FINDINGS OF FACT Hatlestad Short Plat (SP 06-113)

RE: Hatlestad Short Plat (SP-06-113)

Subject: **NOTICE OF APPLICATION for a 4-LOT SHORT PLAT (Hatlestad SP-06-113):**
Chuck Cruse authorized agent for Andrew Hatlestad, landowner, submitted an application for a 4-lot Short Plat pursuant to Kittitas County Code 16.32 on approximately 36.67 acres of land that is zoned Commercial Agriculture, located North of the City of Ellensburg off of Faust Road, Ellensburg, WA 98926 located in the NE 1/4 of Section 16, T.18N. R.18E, W.M., in Kittitas County. Tax Parcel numbers: 18-18-16000-0011, 0012, & 0026.

TO: Scott Turnbull, Community Development Services
FROM: Christina Wollman, Planner II
DATE: November 27, 2006
SUBJECT: Hatlestad Short Plat

KITITAS COUNTY, WASHINGTON

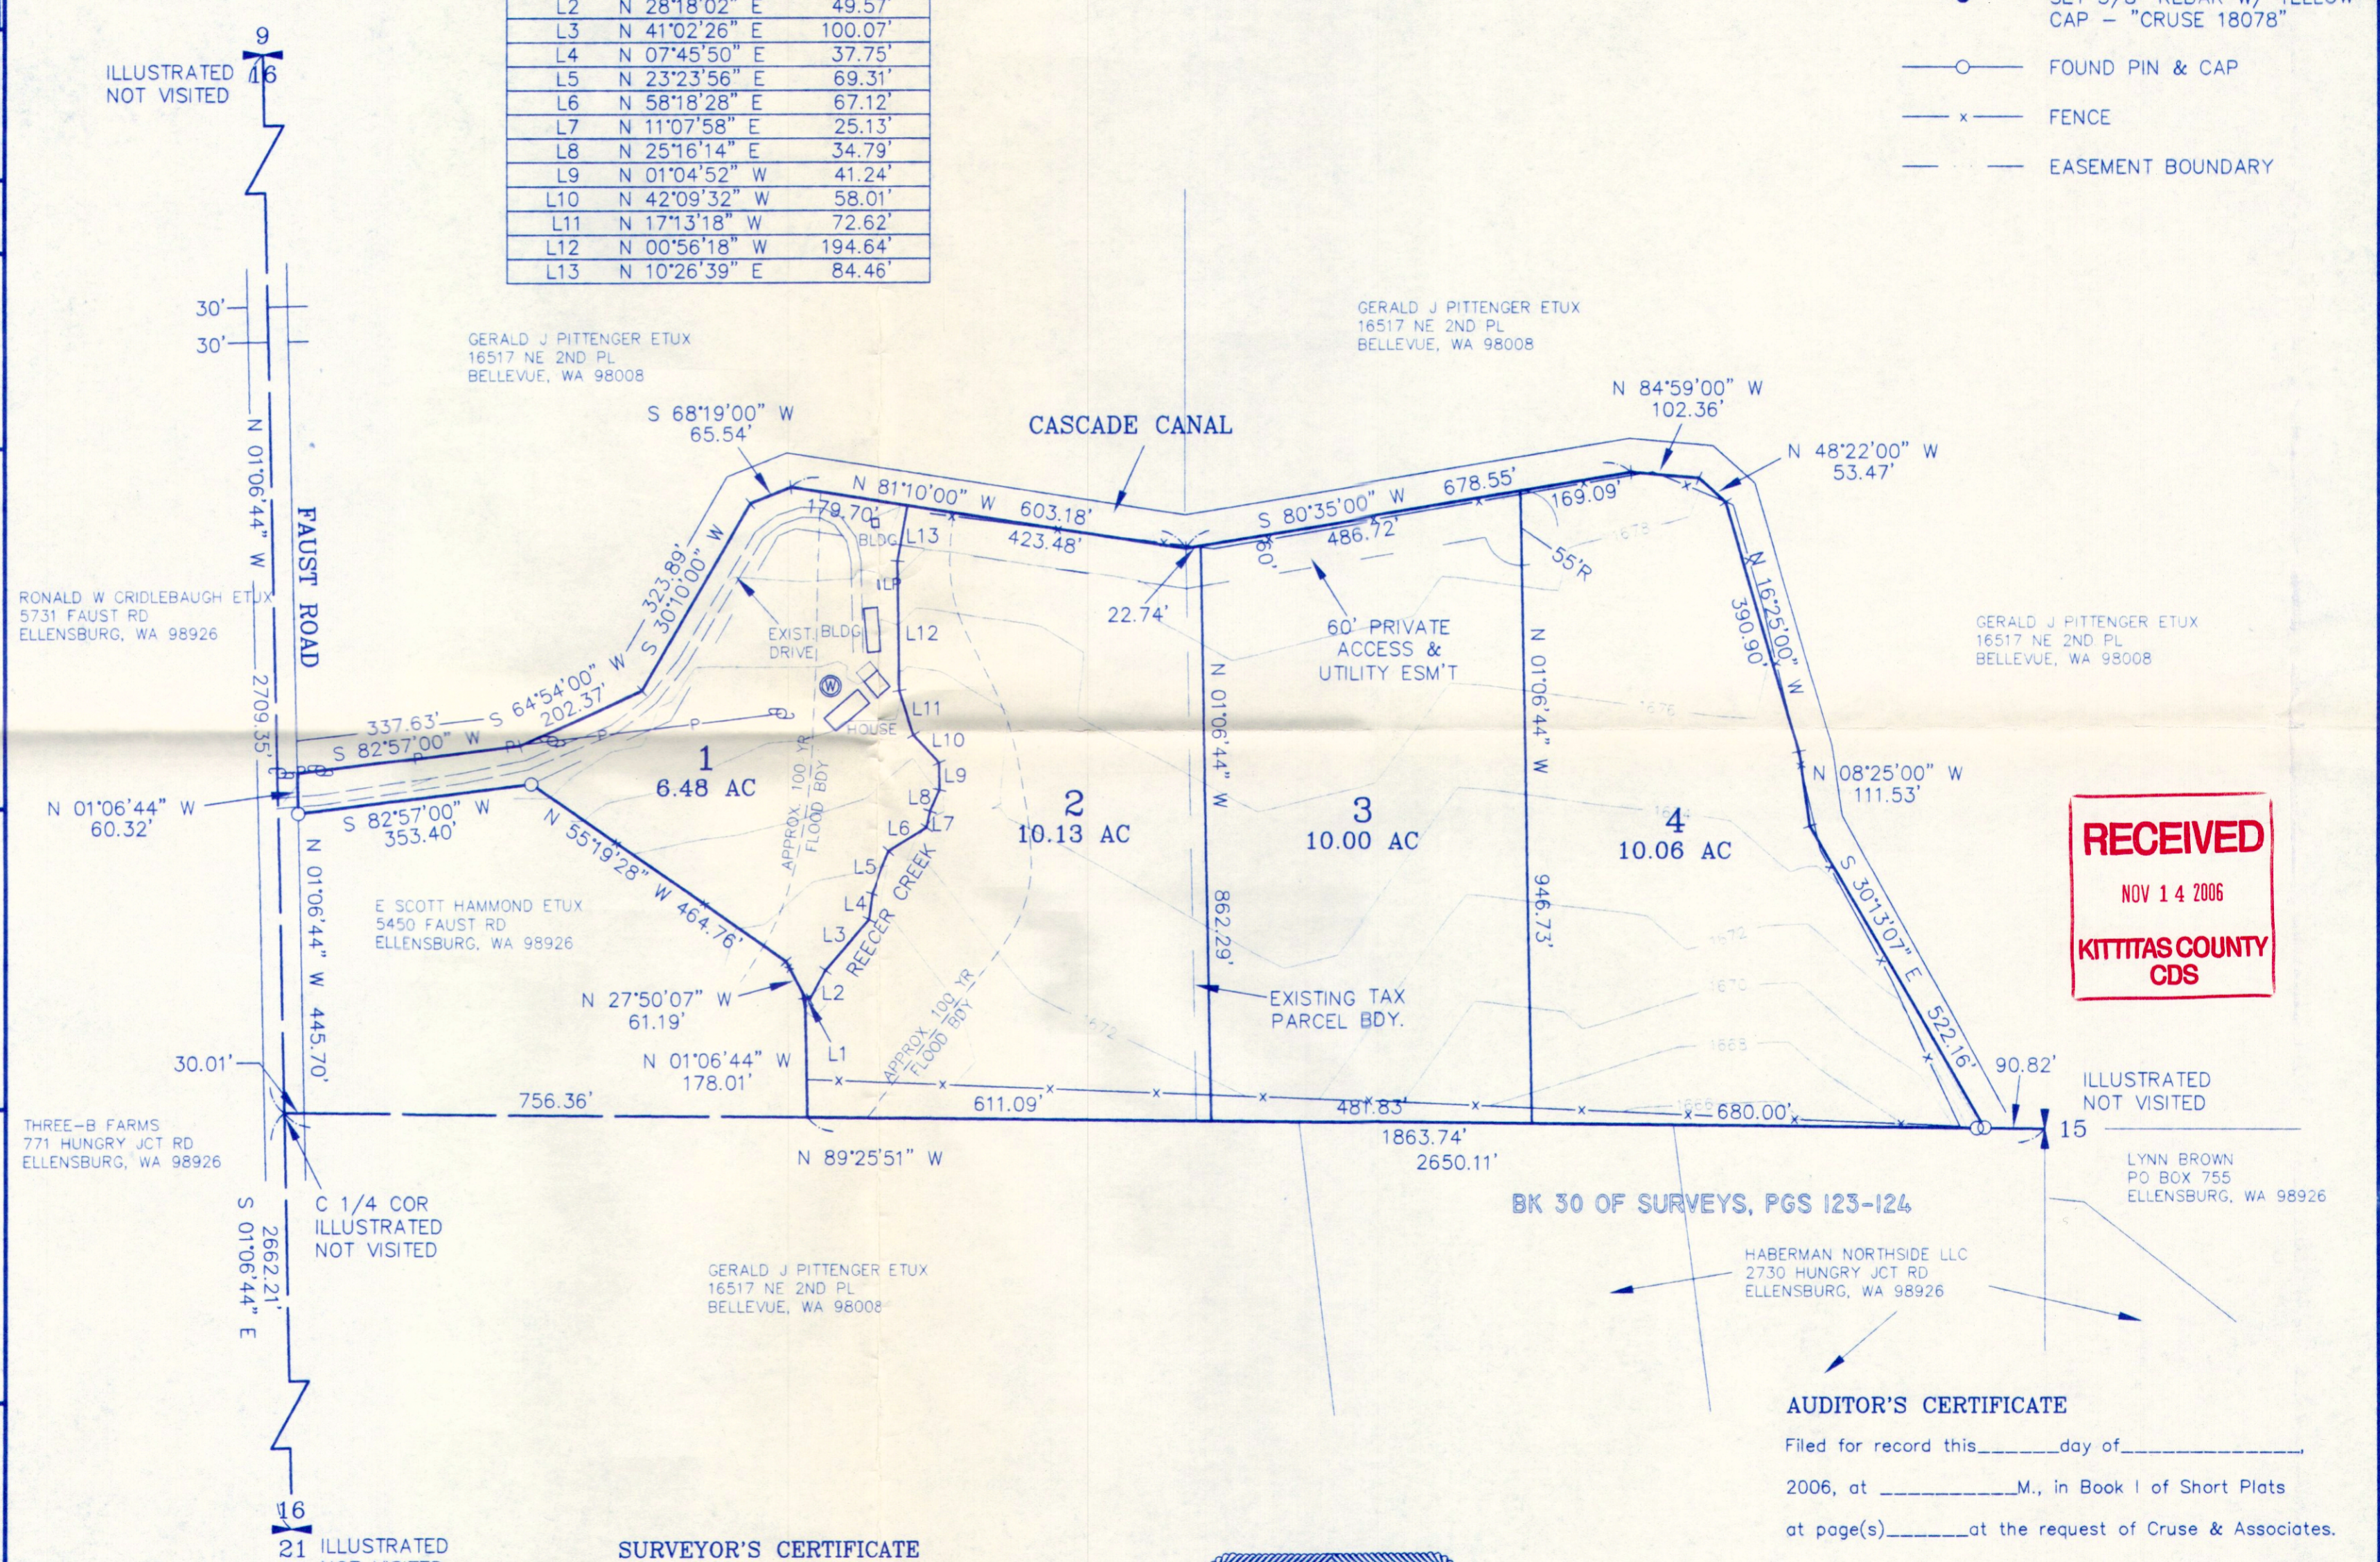
1. Both sheets shall reflect the short plat number SP-06-113.
2. All future development must comply with International Fire Code (IFC) and appendices.
3. All Kittitas County road standards must be met. Attached you will find comments from Kittitas County Public Works. Please contact Christina Wollman at 962-7051 regarding all road standards and access questions.
4. Attached you will find comments from Kittitas County Environmental Health. Please see those documents for required plat notes and information on issues needing completion before final approval of this short plat.
5. Submittal of a Certificate of Title (Title Report) with the final short plat mylar.

4. Private Road Improvements: Access from Faust Road shall be constructed as a Low-Density Private Road. See Kittitas County Road Standards, 9/6/05 edition.

- a. Access easements shall be a minimum of 60' wide. The roadway shall have a minimum width of 20', with 1' shoulders, for a total width of 22'.
- b. Minimum centerline radius will be 60'.

- c. The surface requirement is for a minimum gravel surface depth of 6".
- d. Maximum grade is 12%.
- e. Stopping site distance, reference AASHTO.
- f. Entering site distance, reference AASHTO.

- j. All easements shall provide for AASHTO radius at the intersection of Faust Road.
- k. A paved apron shall be constructed at the intersection of the proposed private intersection and Faust Road.

5. Cul-de-Sac: Permanent deadend streets shall have a turn-around having an outside right-of-way easement diameter of at least 110' (55' radius) at the closed end. See Kittitas County Road Standards, 9/6/05 edition.
